City of Portland, Maine - Building or Use Permit Application

Permit No: 04-1250	Issue Date:	CBL: 036 E019001
------------------------------	--------------------	----------------------------

Location of Construction: 11 Sherman St	Owner Name: Duffy Tammy	Owner Address: 11 Sherman St Apt 1	Phone:
Business Name:	Contractor Name: Kyle Koerber	Contractor Address: Portland	Phone 6175906147
Lessee/Buyer's Name	Phone:	Permit Type: Alterations - Commercial	Zone:

Past Use: commercial 4 family dwelling unit	Proposed Use: commercial 4 family dwelling unit to be returned to the original 5 family	Permit Fee: \$30.00	Cost of Work: \$50.00	CEO District: 2
Proposed Project Description: to transform building back to original 5 family dwelling unit by adding a wall in apt # 1		FIRE DEPT: <input type="checkbox"/> Approved <input type="checkbox"/> Denied	INSPECTION: Use Group: Type	
		Signature:	Signature:	
PEDESTRIAN ACTIVITIES DISTRICT (P.A.D.) <input type="checkbox"/> <input type="checkbox"/> Approved w/Condition <input type="checkbox"/>

# FIRST FLOOR PLAN

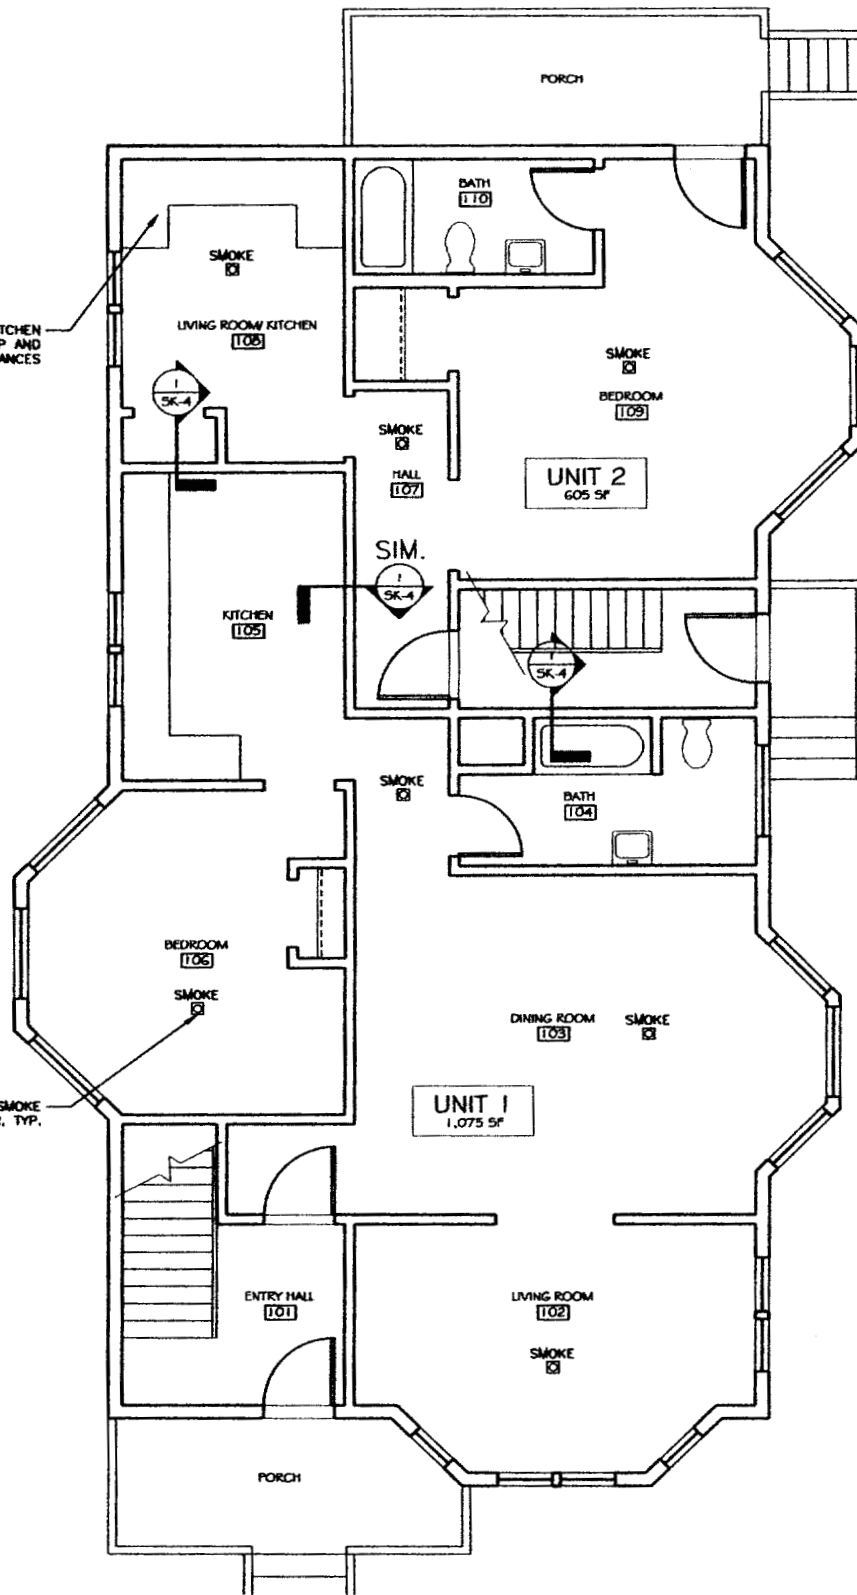
- 1) Any NEW sleeping rooms, that were not previously used as Sleeping rooms must have at least one Egress Window.

- 1) smoke detectors shall be installed in accordance with NFPA 101 life safety code

10/15/2004-mjn: New tenant separation wall must have a 1 hour rating, have a question about Smoke Detectors, Left message w/ applicant.
